Charlotte Department of Transportation

Memorandum

Date: October 31, 2008

Subject: Rezoning Petition 08-155: Located on the east side of South Tryon Street
between Yorkdale Drive and Thornfield Road

S. TRYON STREET
 REZONING PETITION NUMBER _____
 JDR COMMUNITIES
 CONCEPTUAL SITE PLAN

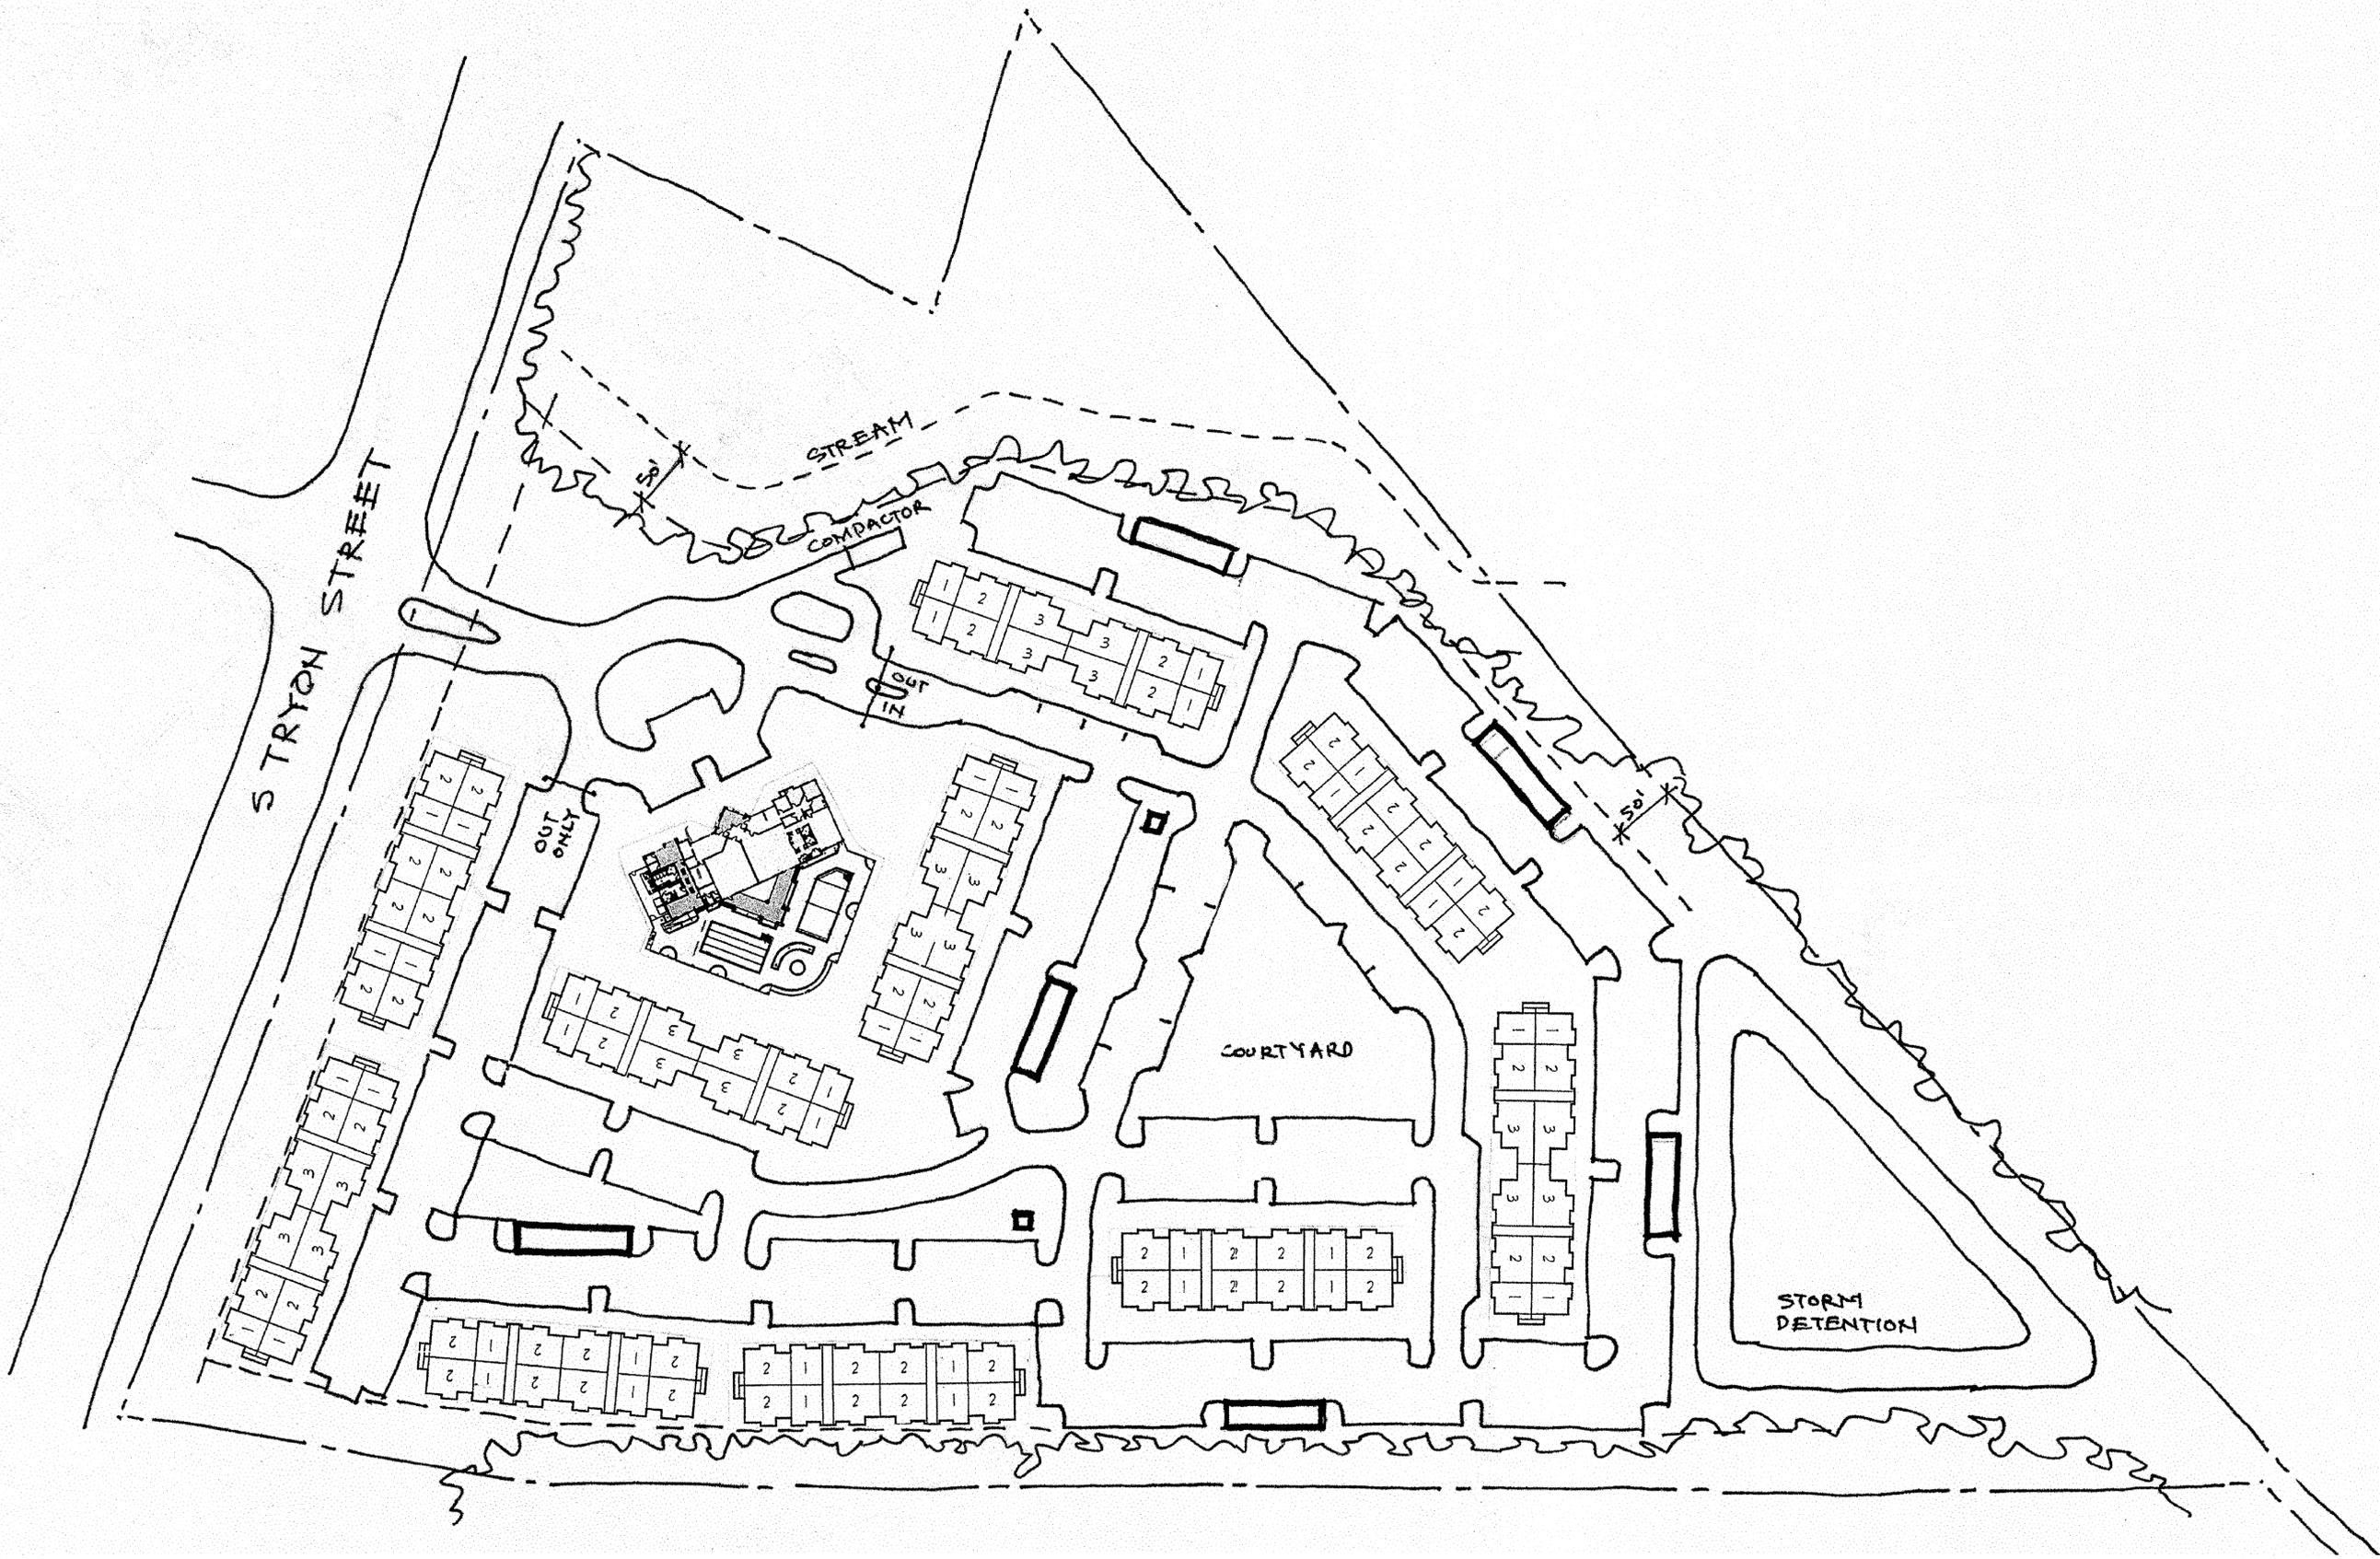
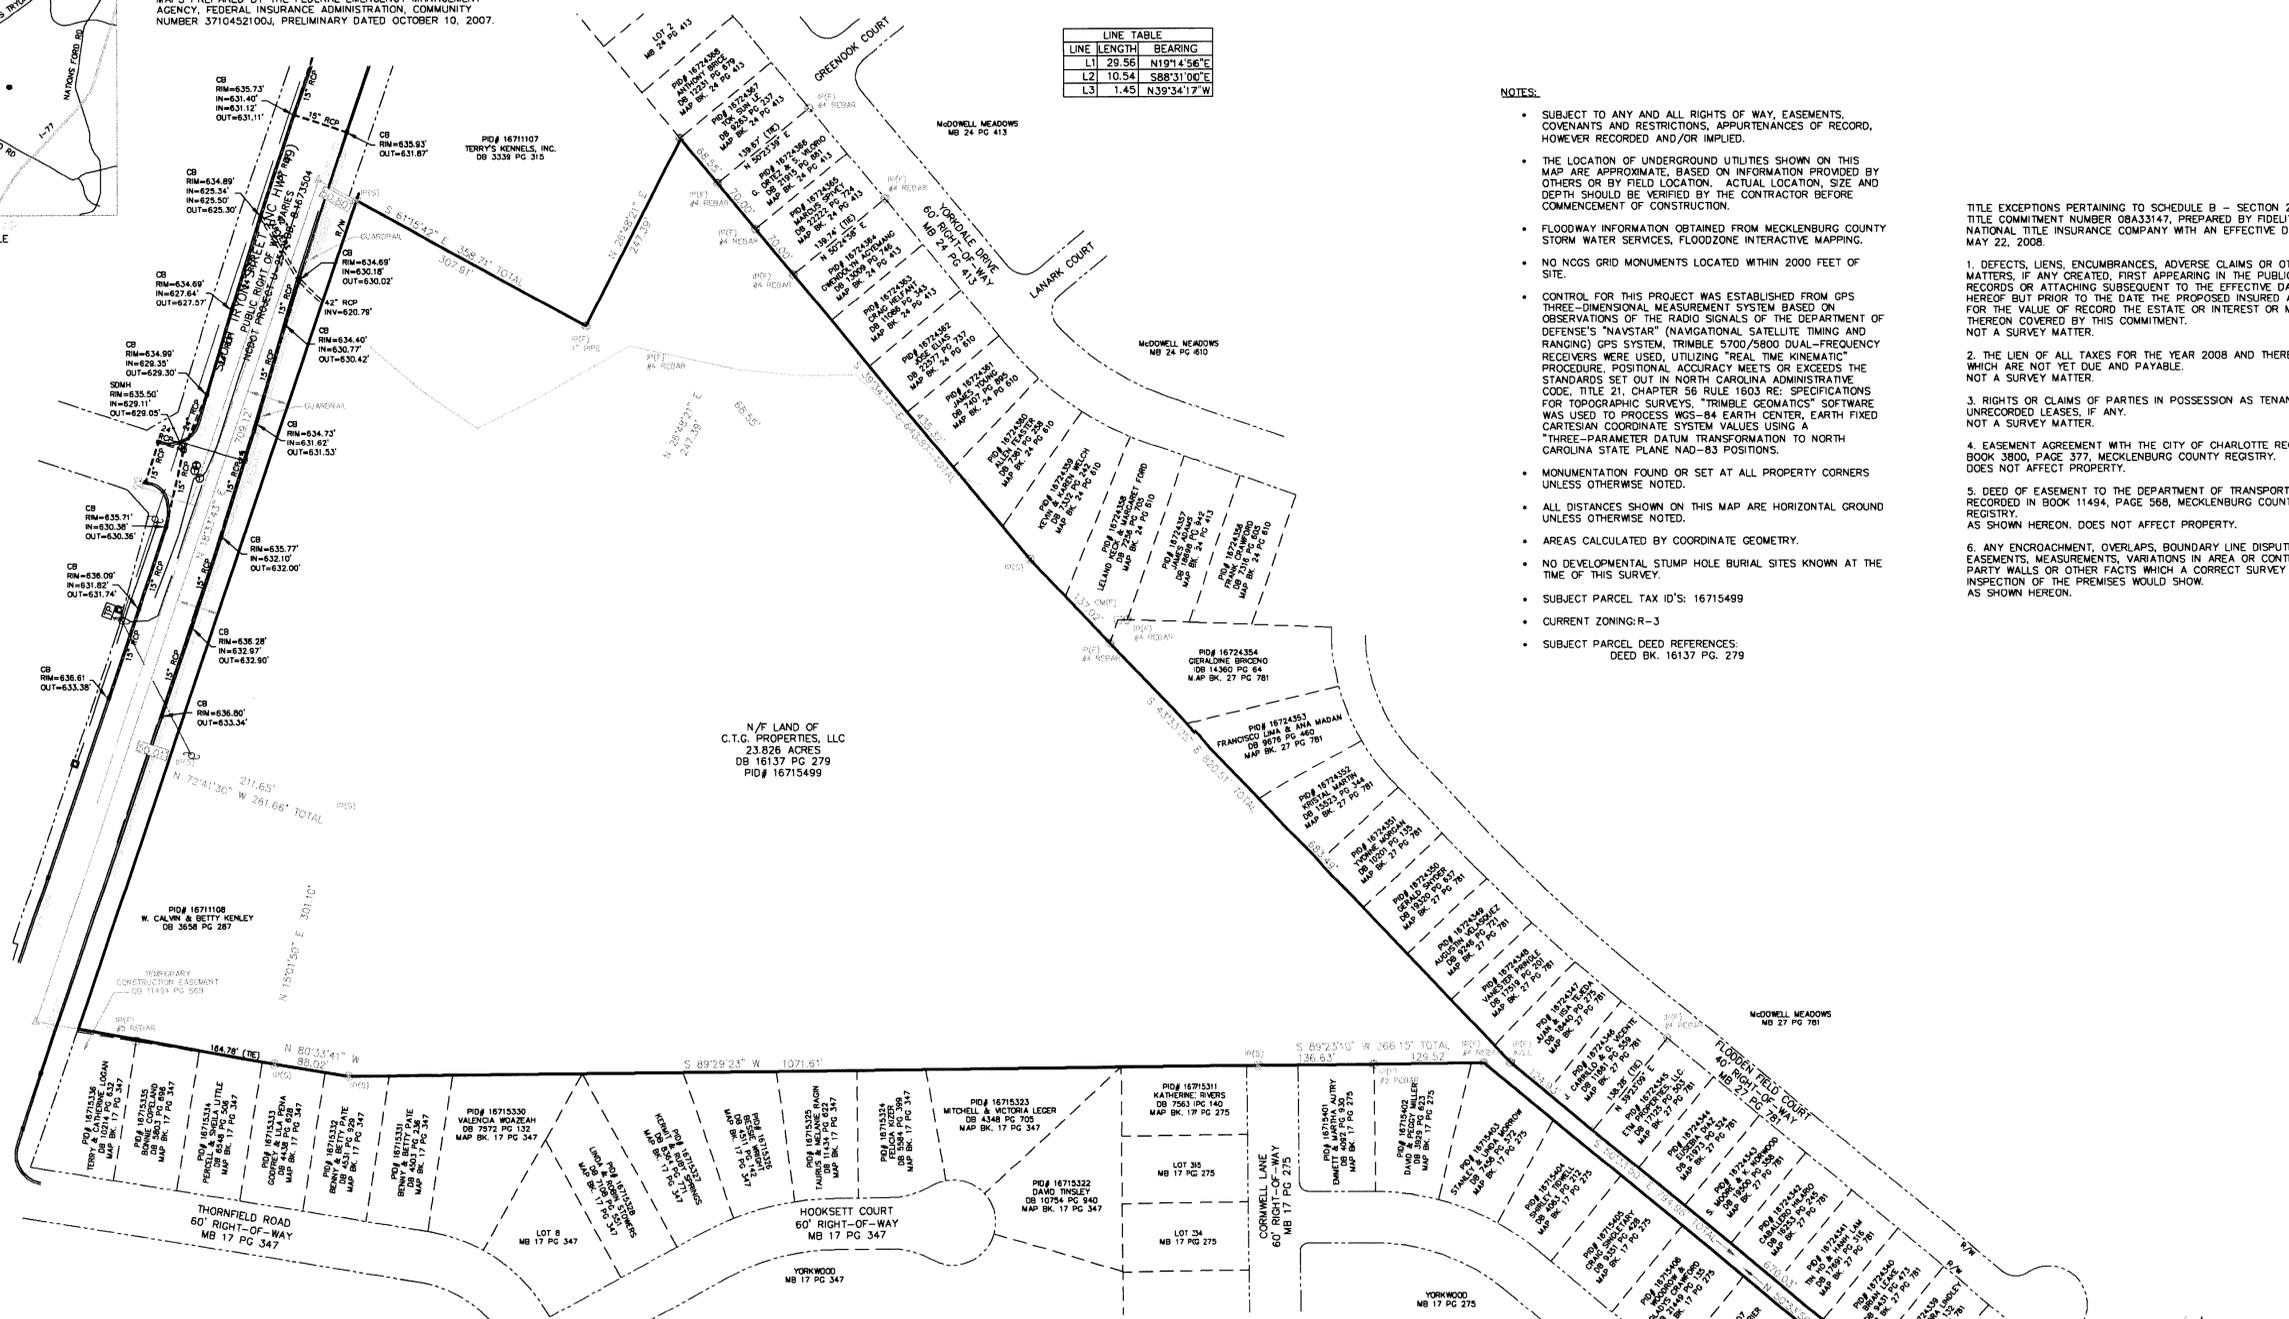
1. The developer needs to dedicate a 60-foot wide public right-of-way, which could be a network of public streets, between the full-movement access point on South Tryon Street located opposite Olde Whitehall Road and Cormwell Lane. Within such right-of-way, the developer needs to construct a new street following the Urban Street Design Guidelines (USDG) for a Local Residential Street – Wide. Such street has a 35-foot back-of-curb width with 7-foot parking lanes, 8-foot planting strips and 8-foot sidewalks (for densities over 12 units per acre).

2. CDOT has determined that a left-turn lane on South Tryon Street is necessary to serve the traffic using the proposed private driveway connection for this site. The engineering design and construction of the left-turn lane is the responsibility of the owner and shall be performed by a professional engineer registered in the State of North Carolina who has roadway design experience. The left-turn lane needs to follow the NCDOT design guidelines with a minimum of 150 feet of storage and will be reviewed during subsequent permitting processes.

3. The developer needs to construct 8-foot planting strips and 6-foot sidewalks along South Tryon Street, replacing the existing back-of-curb sidewalks.

4. In the Development Notes, the portion "All access points will be gated" needs to be removed from note 3.
5. The existing geometric features, (curb & gutter, sidewalk, accessible ramps, etc.) need to be shown on the site plan in order to further evaluate this petition.

1. The extension of Cormwell Lane through the proposed development should T into the public street connecting to South Tryon Street described above, so as to provide built-in traffic calming. CDOT encourages the developer to consider a roundabout at this intersection.

South Tryon Street is a major thoroughfare requiring a minimum of 100 feet of right-of-way. The developer/petitioner should convey right-of-way in fee simple title to meet this requirement, measuring 50 feet from the centerline of the roadway.

Adequate sight triangles must be reserved at the existing/proposed street entrance(s). Two 35' x 35' and two 10' x 70' sight triangles are required for the entrance(s) to meet requirements. All proposed trees, berms, walls, fences, and/or identification signs must not interfere with sight distance at the entrance(s). Such items should be identified on the site plan.
